Our Ref: RV/2017/ENQ/00083

Proposal: Conversion of the existing nursing home into three dwellings and the erection of two additional dwellings at Showley Brook Rest Home, 10 Knowsley Road, Wilpshire.

Pre-Application Enquiry Response

drawing title: PROPOSED SITE PLAN		
scale: 1:200 @ A2		
drawn: DS	checked: PH	
date: 22/03/18		
project no: PHA/123	fig. no: 200	rev: -

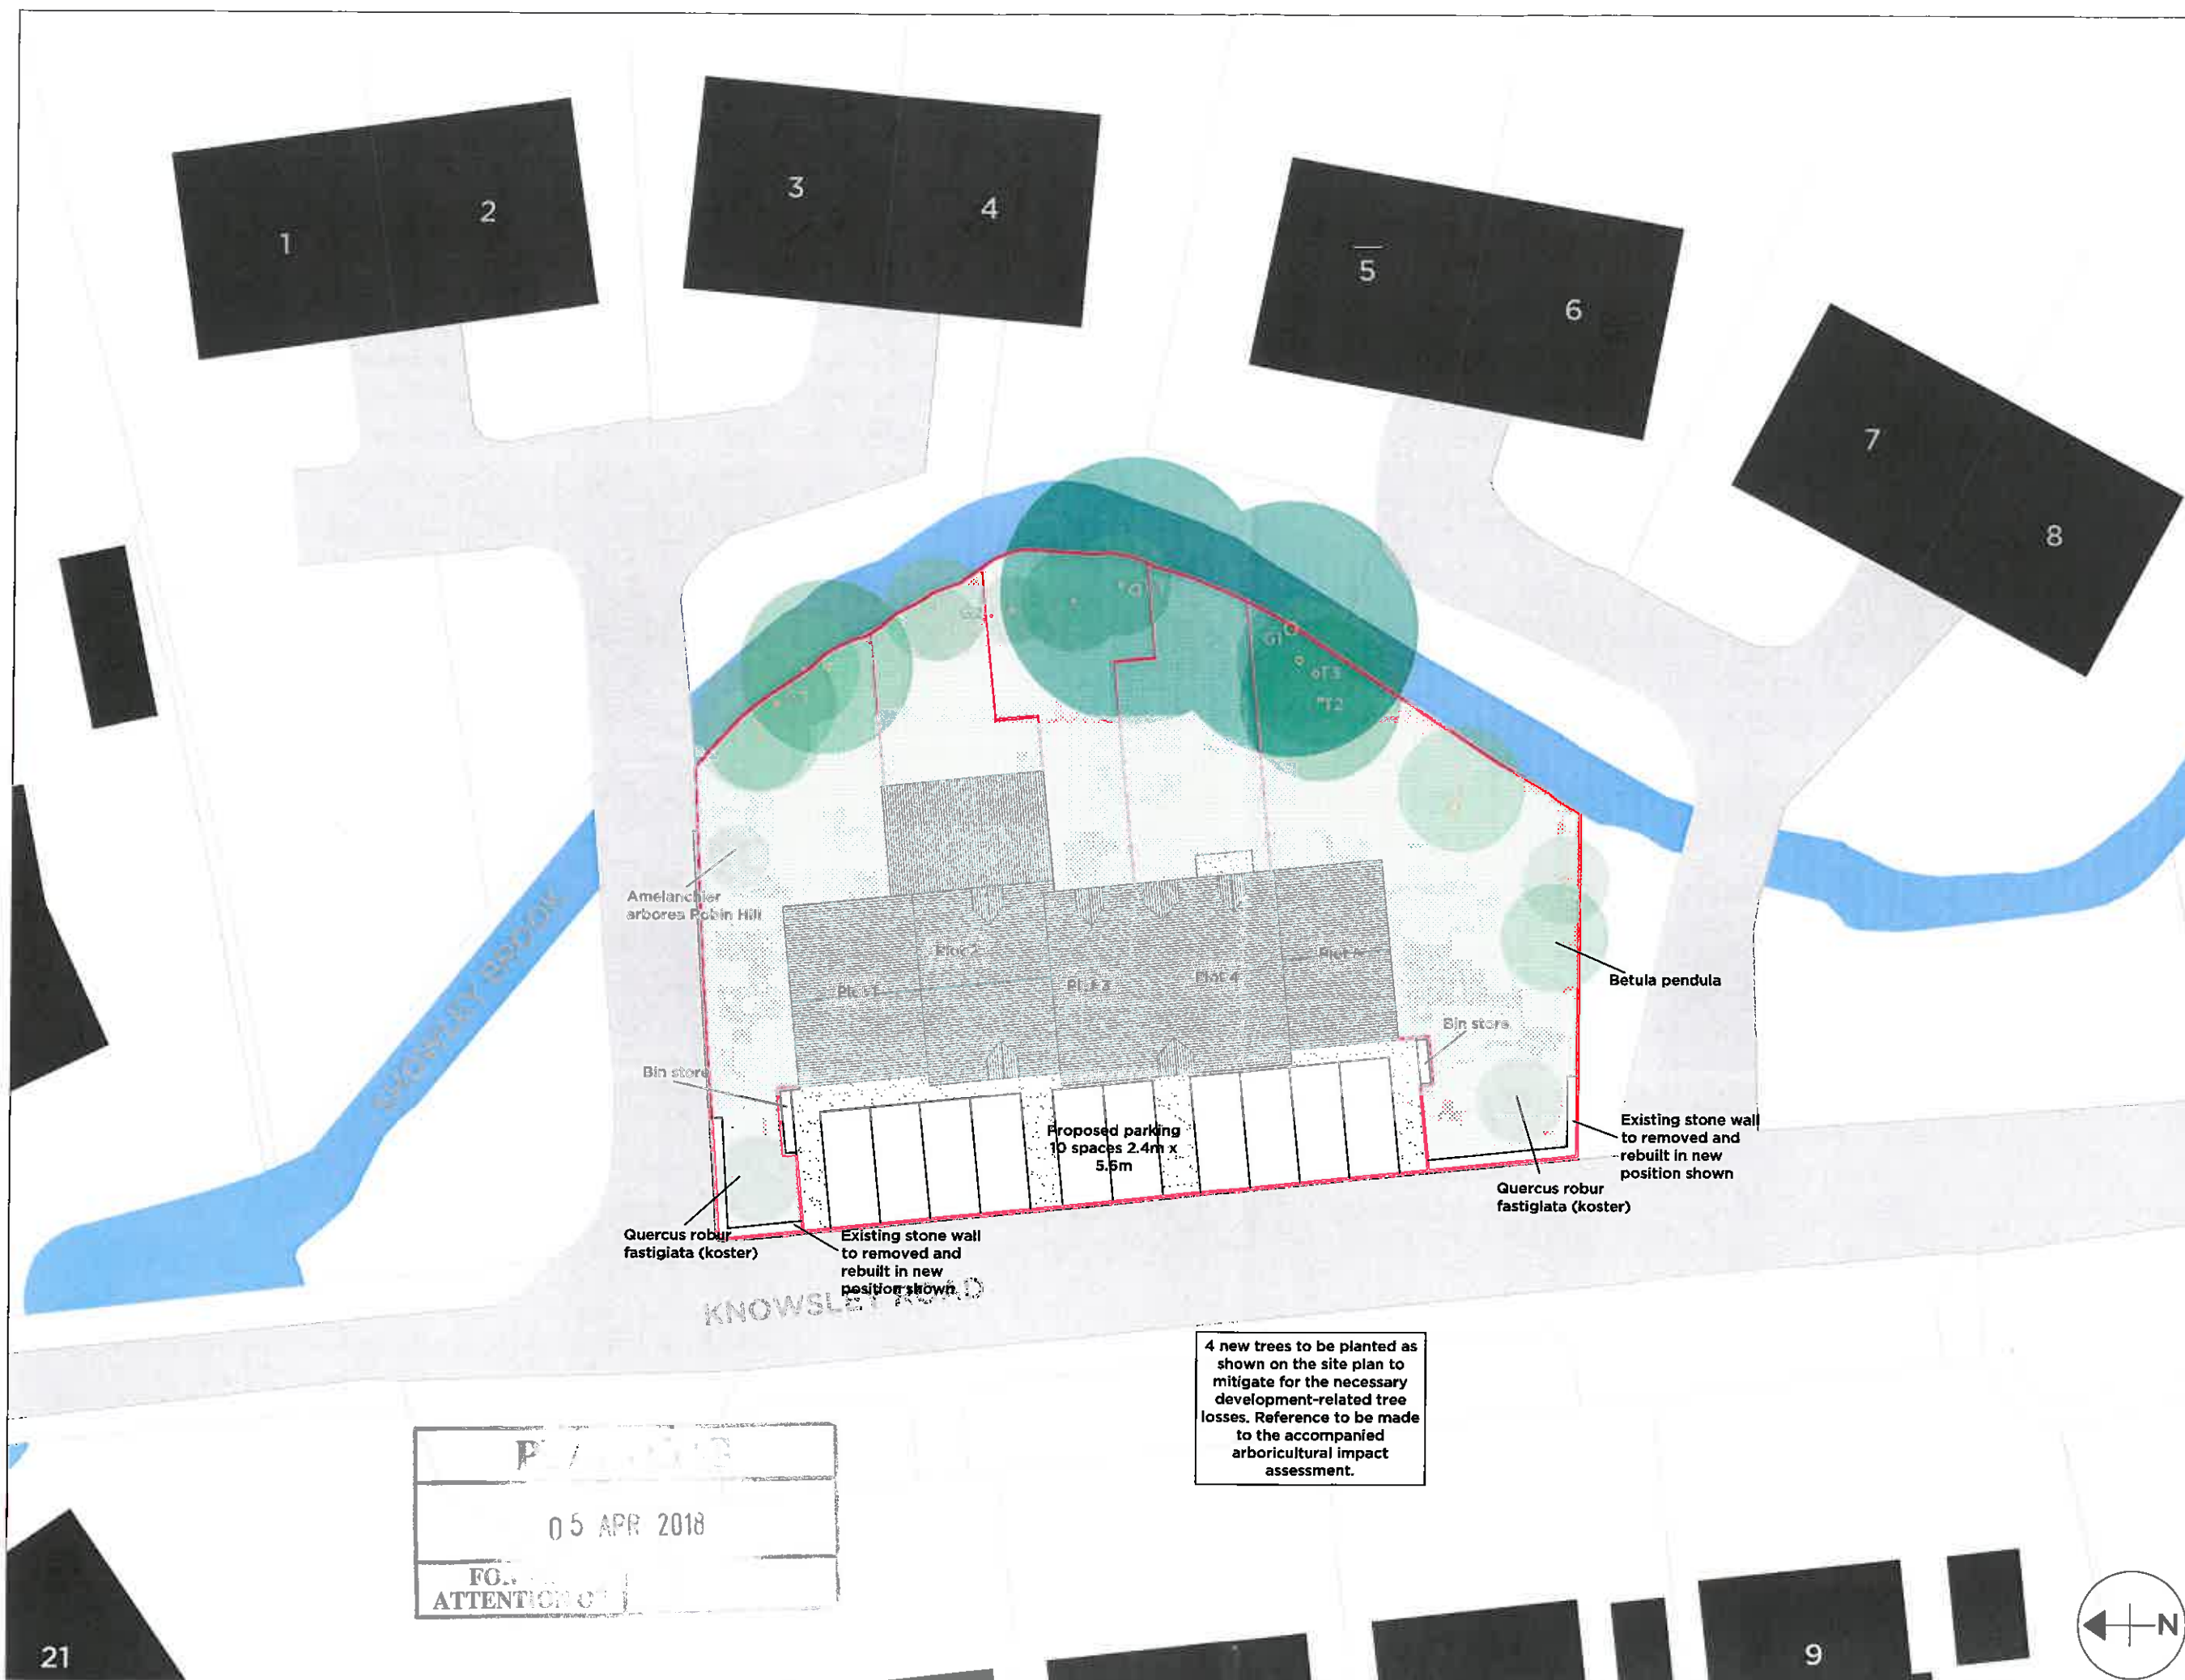
I consider that the introduction of five parking bays to the frontage of the properties would result in visual harm to the appearance of the street scene and would also result in the loss of the majority of the low stone boundary wall to the frontage of the site which in my opinion is a positive feature.

I note that five parking bays for two vehicles each are proposed to the frontage of the properties. I have strong concern that this arrangement will conflict with other vehicles on Knowsley Road and vehicles entering and leaving the bungalows opposite (nos. 11,15 & 17). LCC Highways no longer offer pre-app advice to the Authority, however they are now offering pre-app advice to individuals and planning agents for a fee. I would strongly suggest that you contact them directly prior to a formal application being submitted in which further details can be found via the following link:

The plan submitted (PHD/SB/200) shows that the rear garden areas of each property will continue up to 'Showley Brook'. It is not clear at this stage as to whether works will be carried out within close proximity of the Brook. As part of any subsequent application detailed plans should be submitted clarifying any fencing or hard and soft landscaping within close proximity of the Brook. For information, the Authority are likely to consult the Environment Agency and the Lead Local Flood Authority (LLFA) in which case any observations or comments received will be a material consideration.
